Our ref: DOC21/985542

Your ref: SSD-6084-Mod-3

Austen Quarry – Modification 3 – Biodiversity offsetting

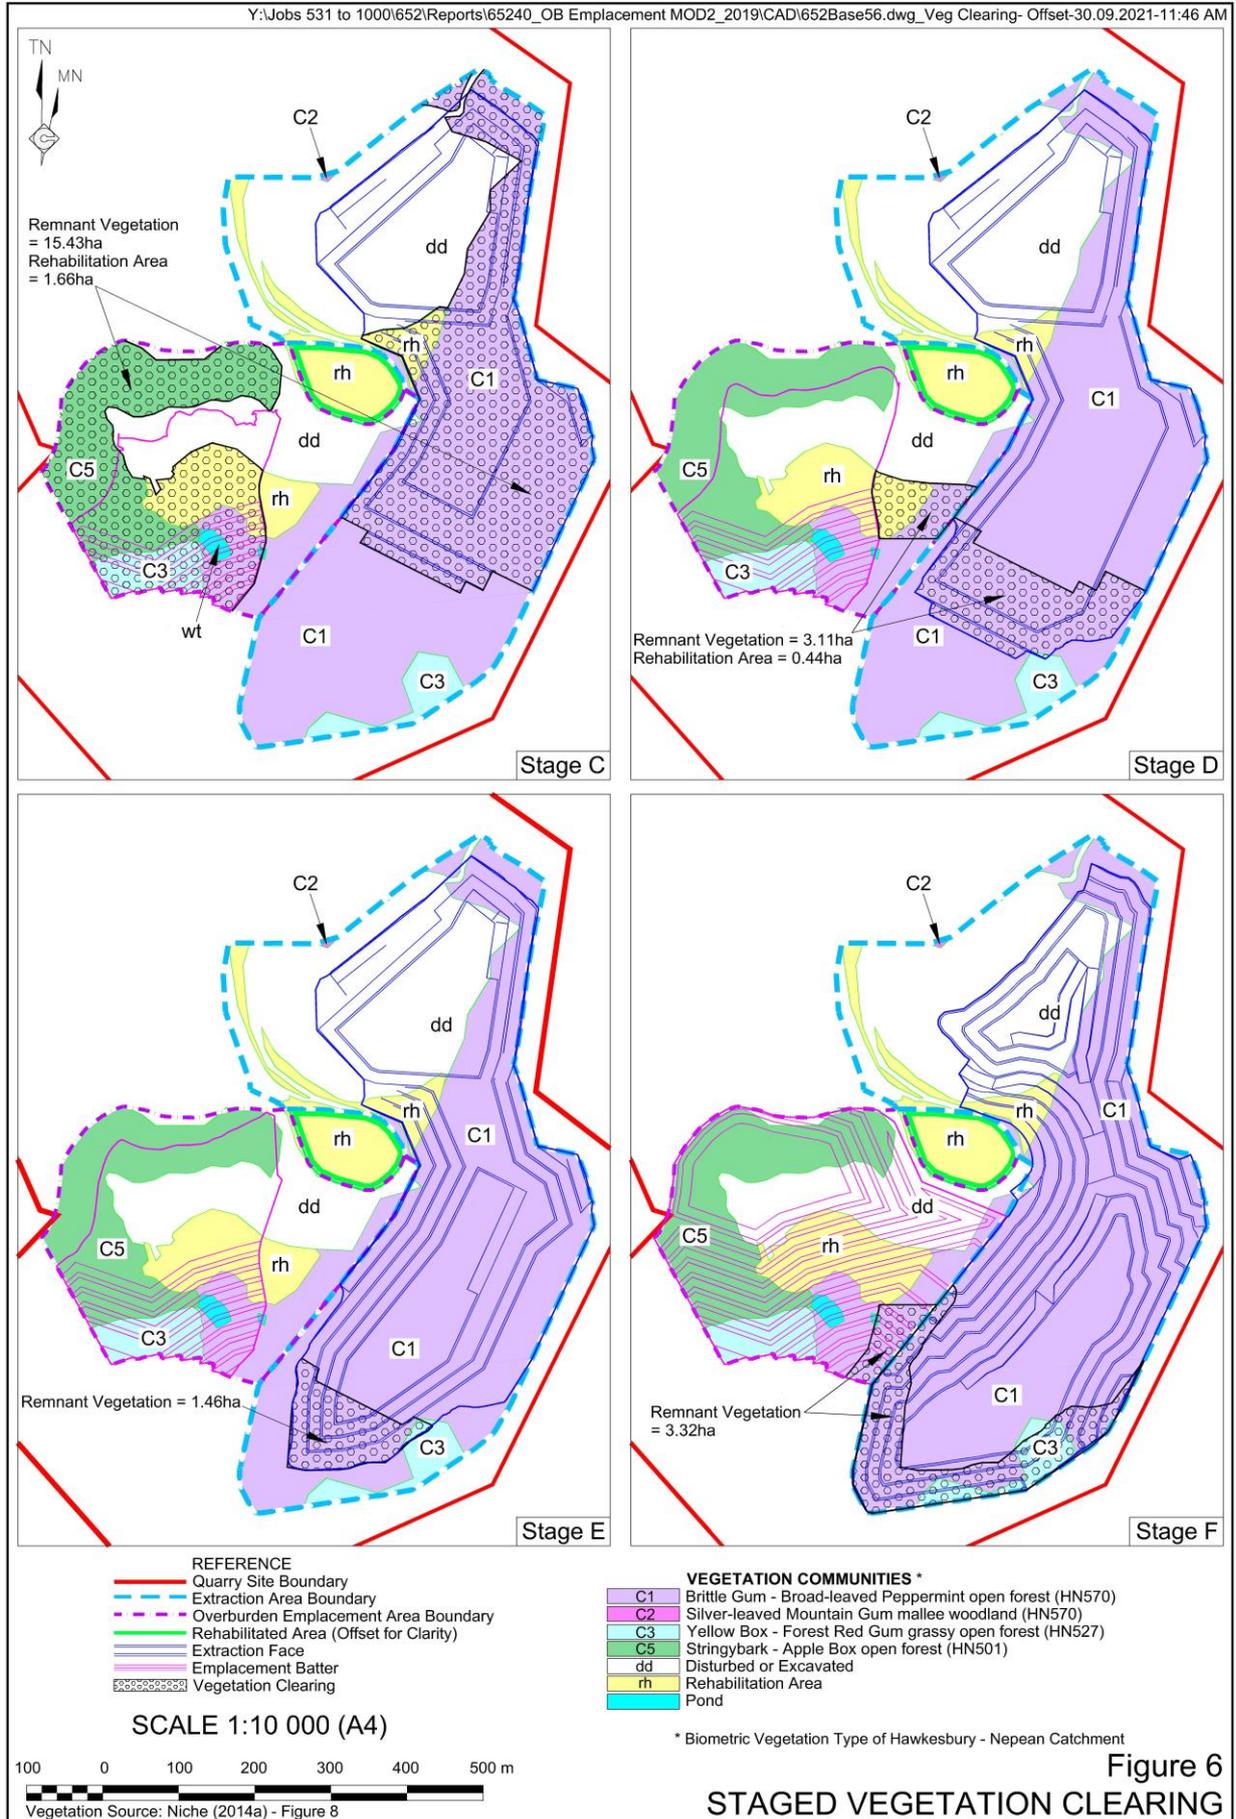
The proponent now intends to stage biodiversity offsets with the credits to be retired prior to the progression of disturbance in each stage.

The ecosystem credits that have been calculated for each stage are based on the lower credit numbers for PCTs 840 and 649 in the statement of reasonable equivalence. As the lower numbers only apply to the land-based offset area, the higher credit liability will need to be used.

- 7.1 The ecosystem credits to be retired for each stage be recalculated using the higher credit liability for PCTs 840 and 649.
- 7.2 Staged retirement of biodiversity credits can occur provided the total credits retired match the requirement in the statement of reasonable equivalence.
